CITY OF ALBUQUERQUE

January 3, 2012

Re: Fire Station No. 7, Grading and Drainage Plan
Engineer's Stamp dated 12-19-11 (K11/D079)

City Project No. **8006.91** Zone Map No. **K-11** DWG. **C-101** Sheet **Of**

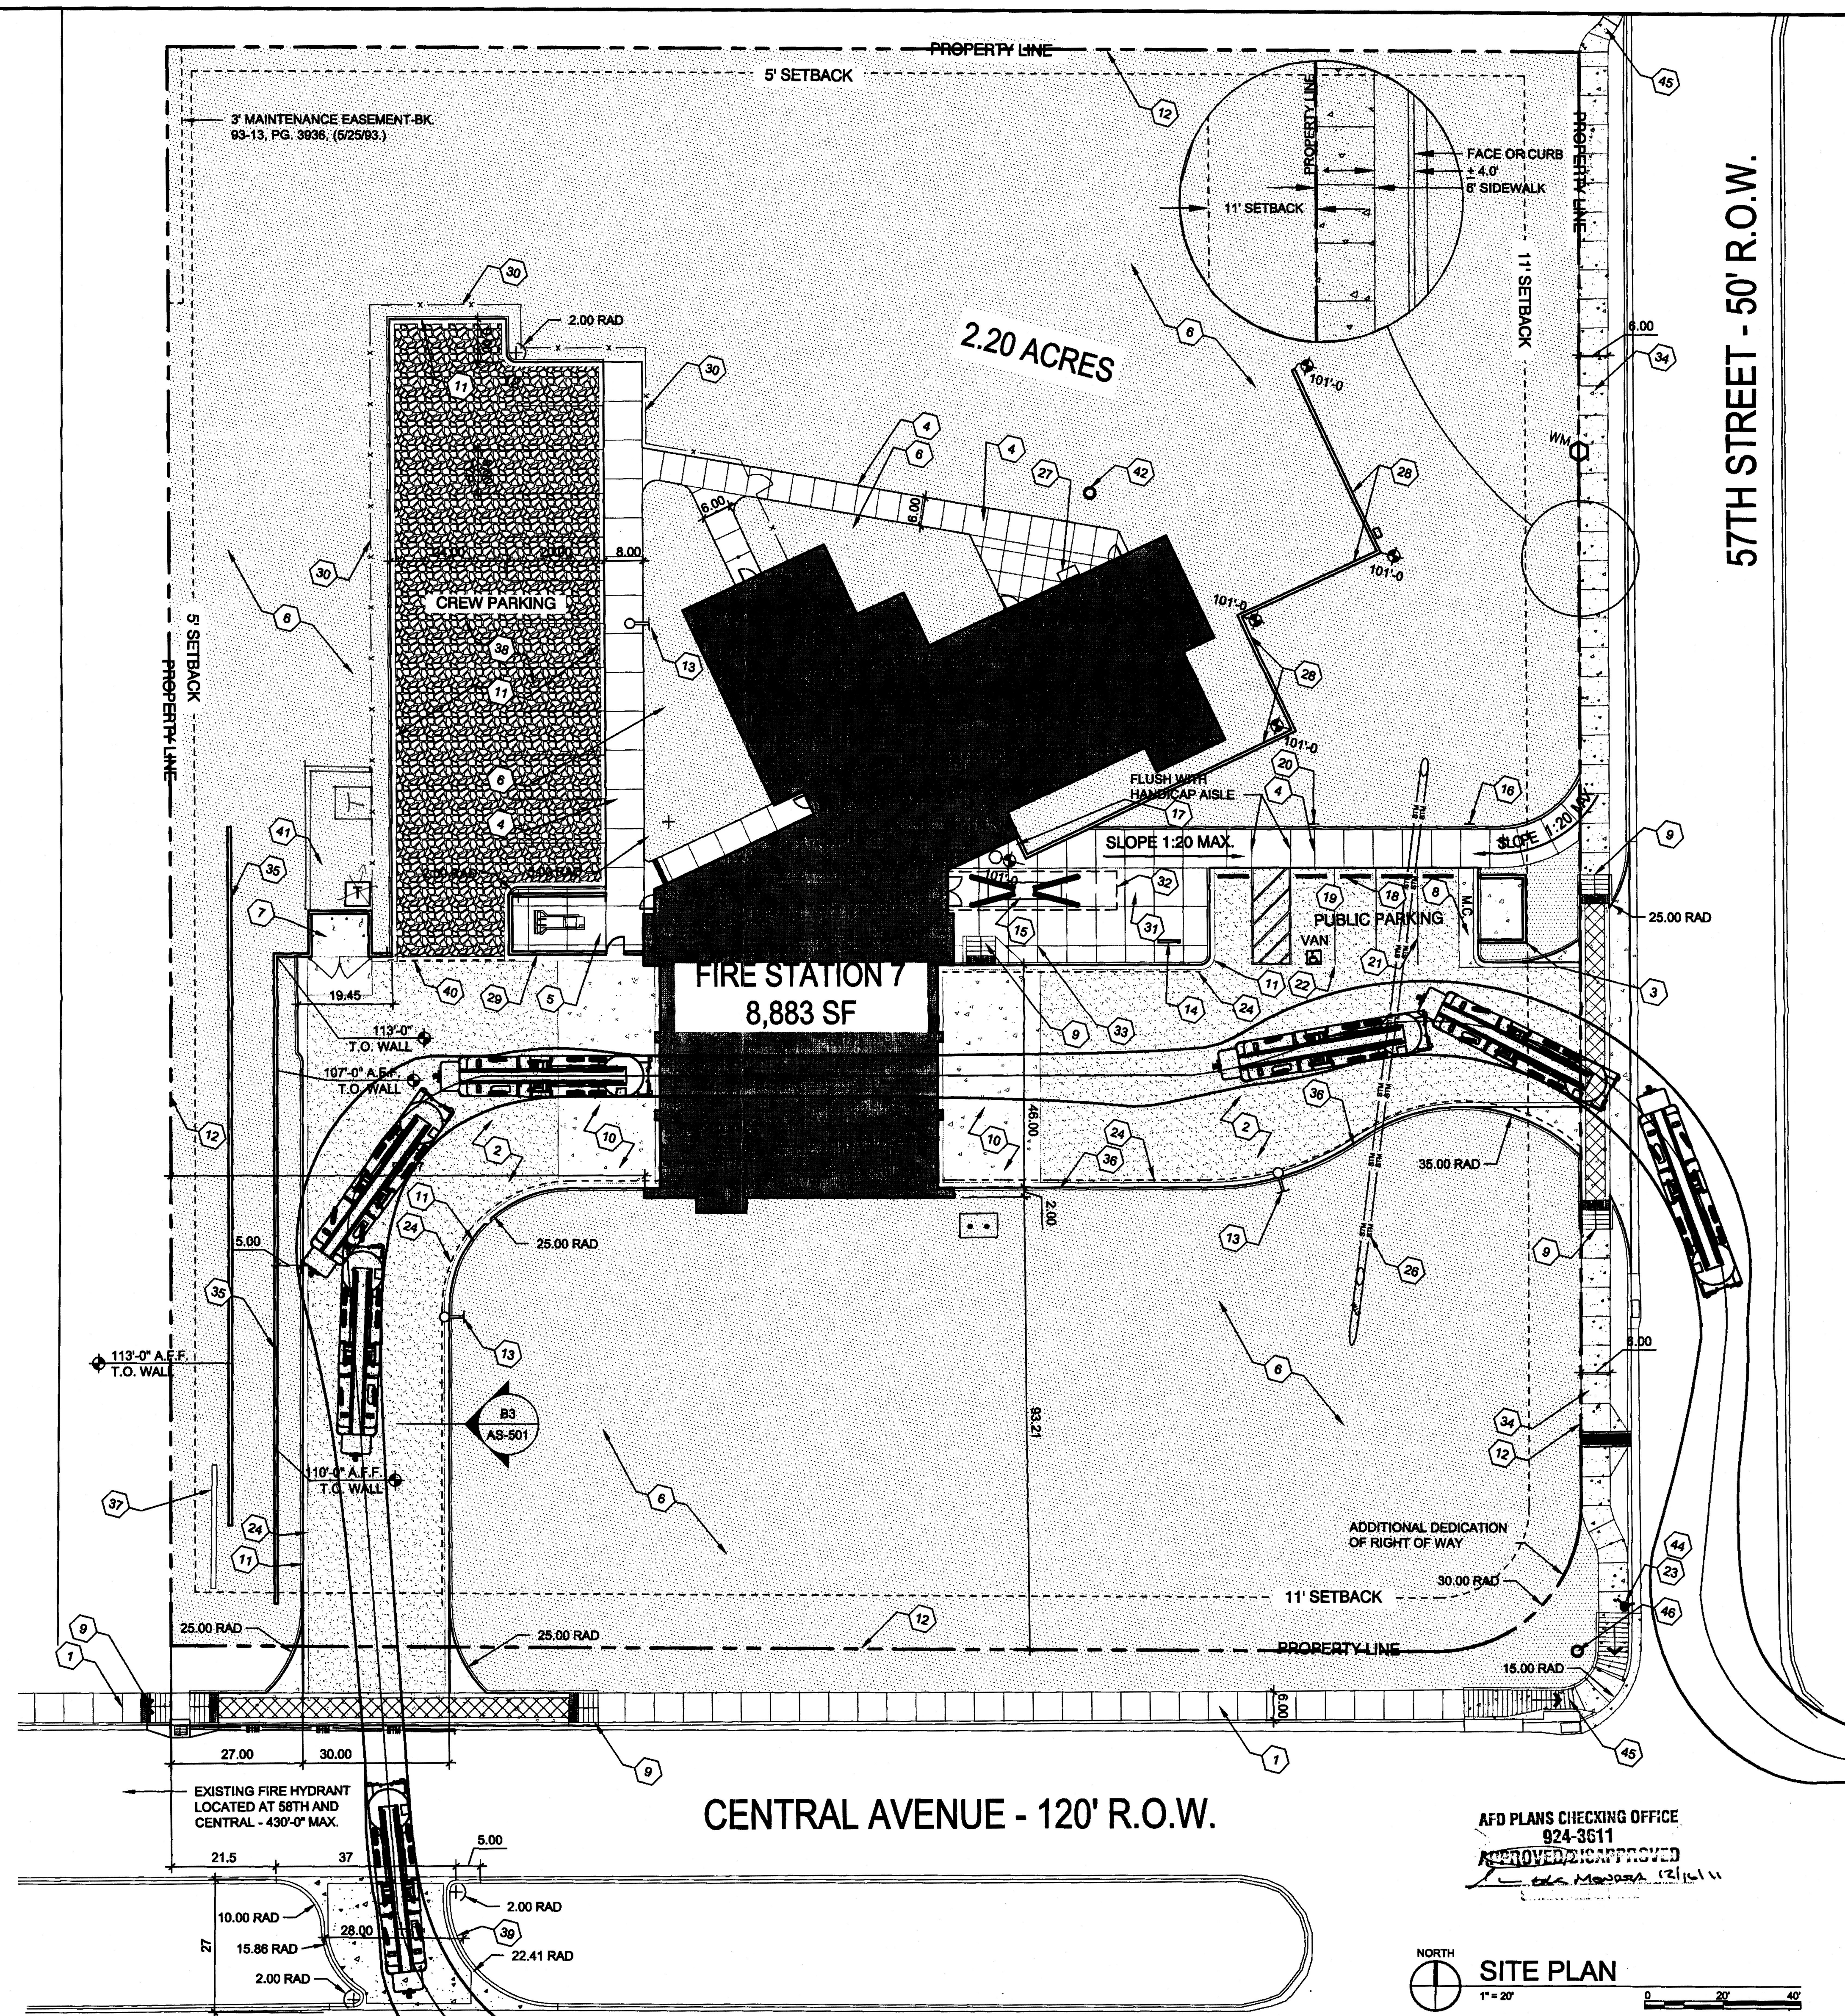
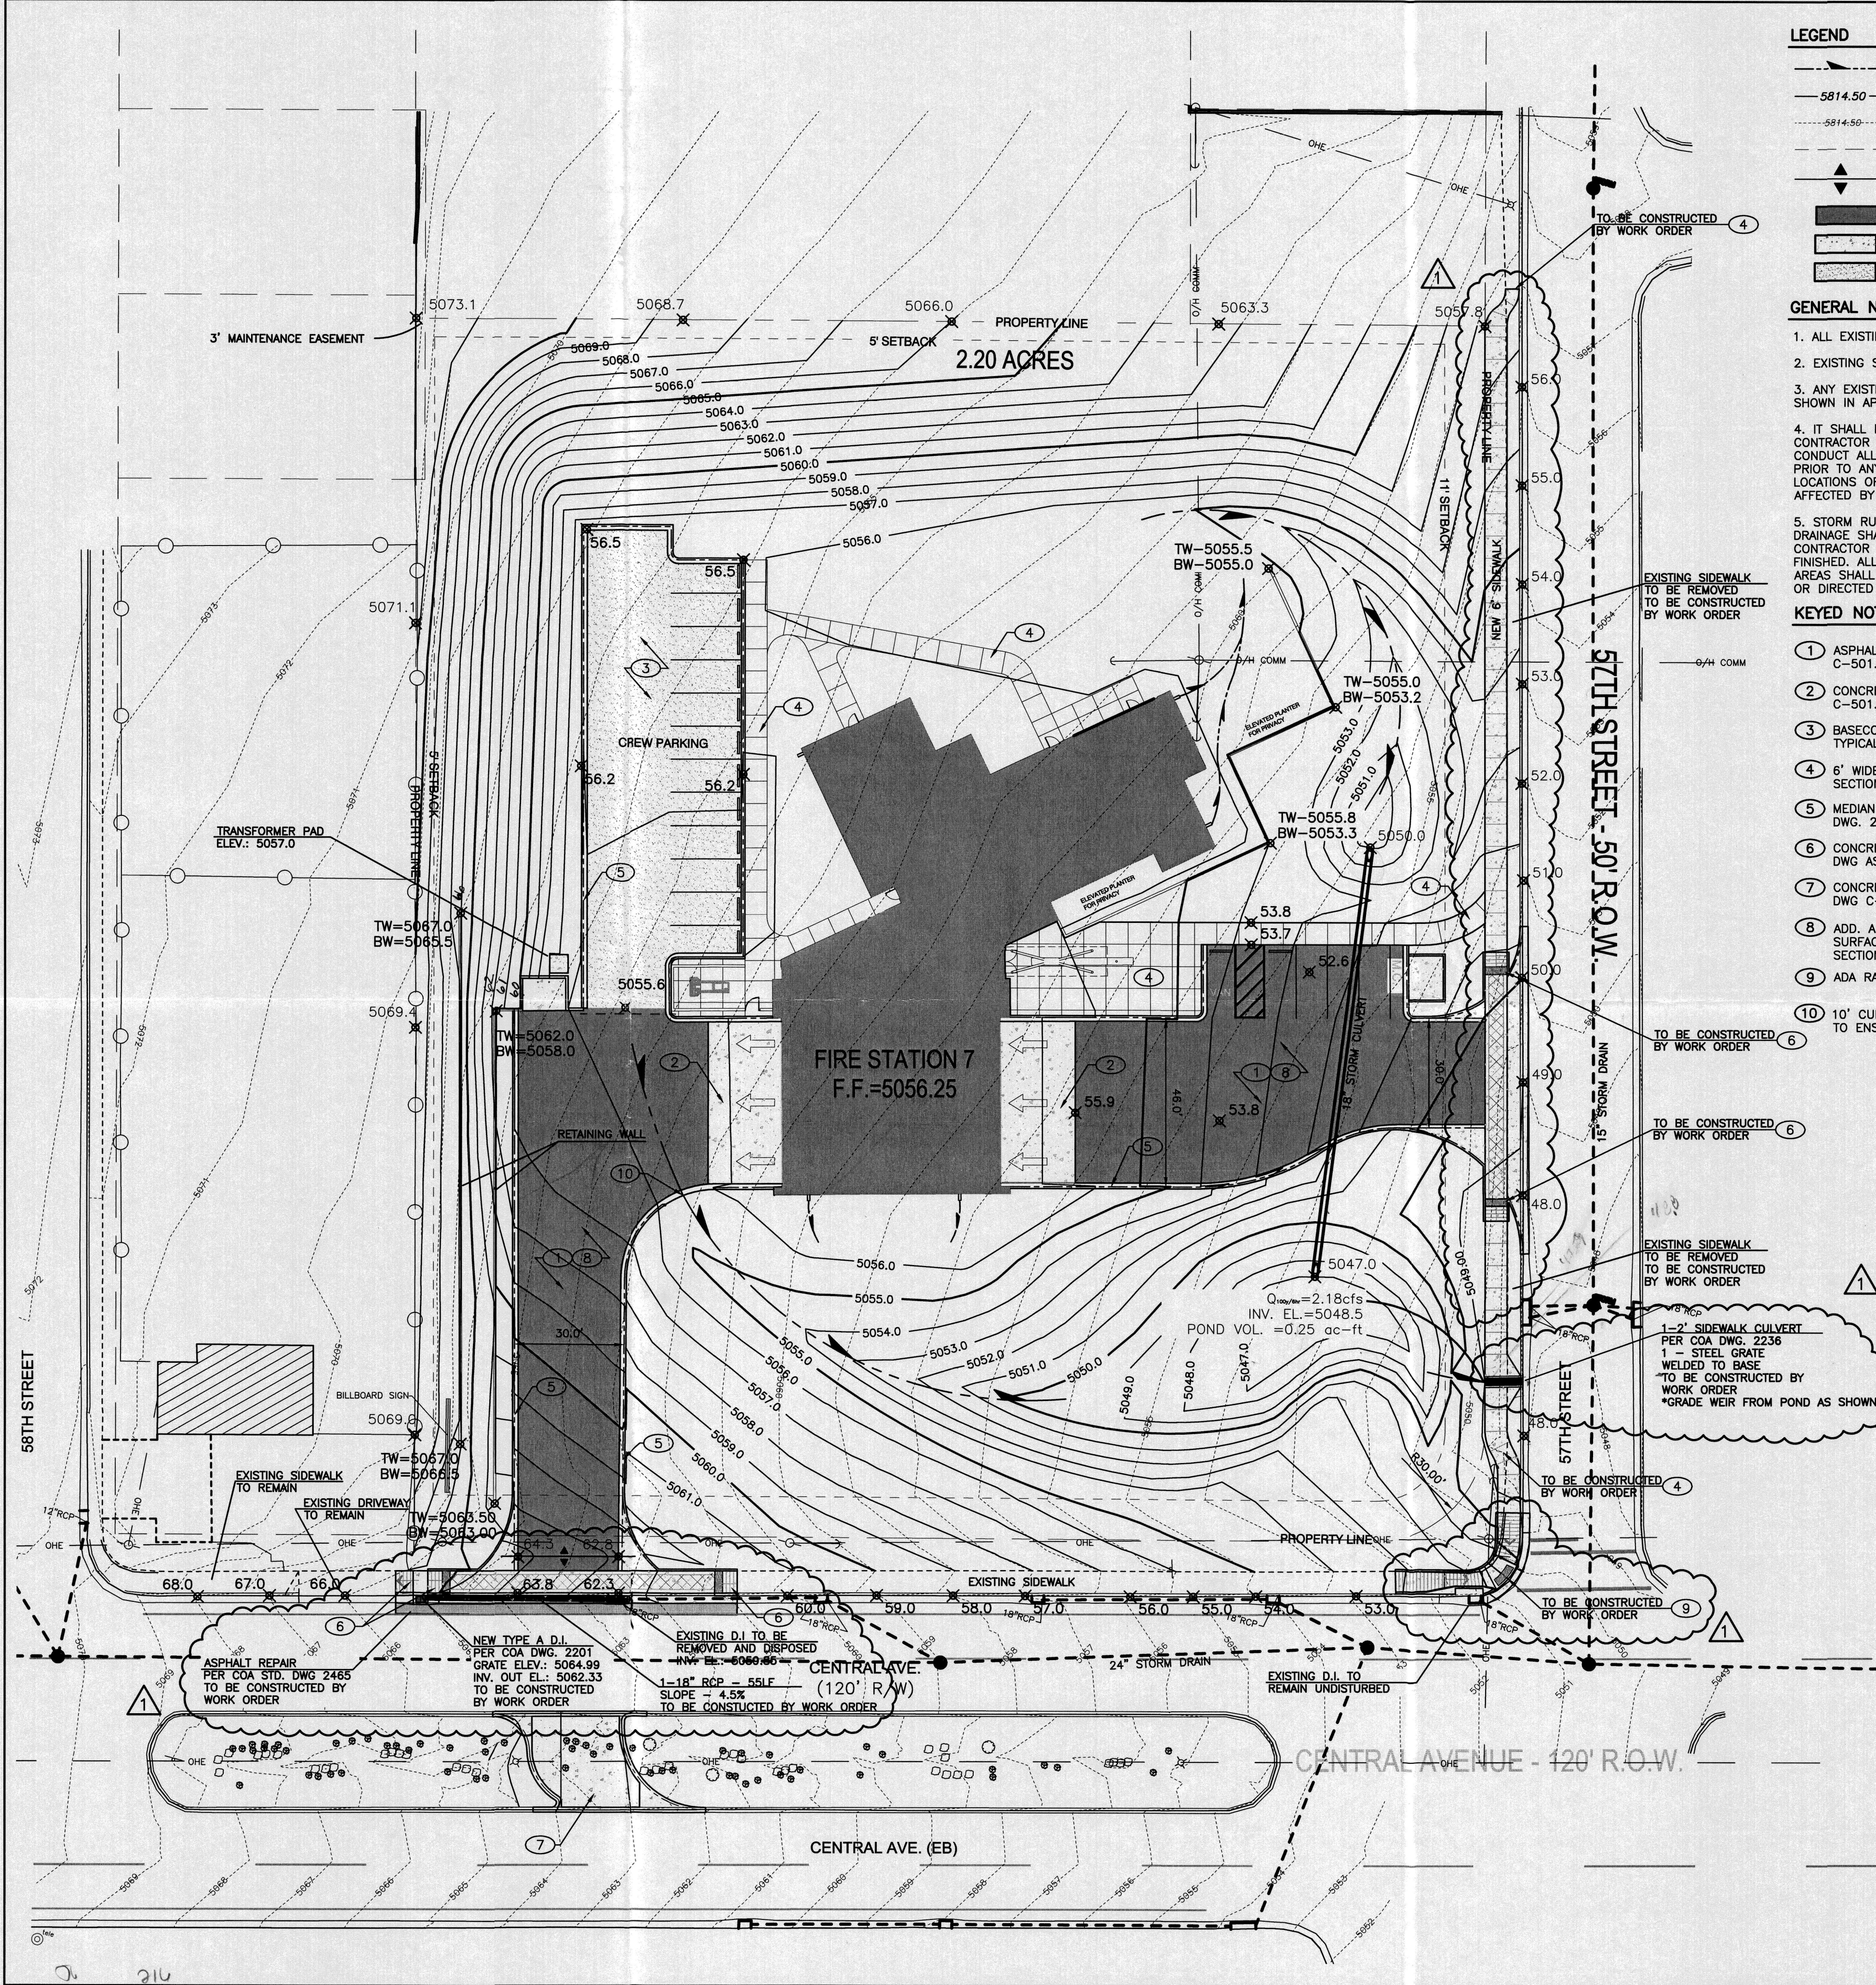
- Provide a narrative, drainage calculations and Flood Zone information.
- The items to be built by Work Order (infrastructure List items), should have a note similar to "to be constructed by Work Order".
- Add TW/BW elevations for the retaining wall east of the building.
- Hydrology approved a 2' wide sidewalk culvert on 57th St, at DRB. The capacity of these culverts is approximately 1.8 cfs/linear foot, limited by the entrance condition. What is the proposed flow to the sidewalk culvert and is it the correct size?
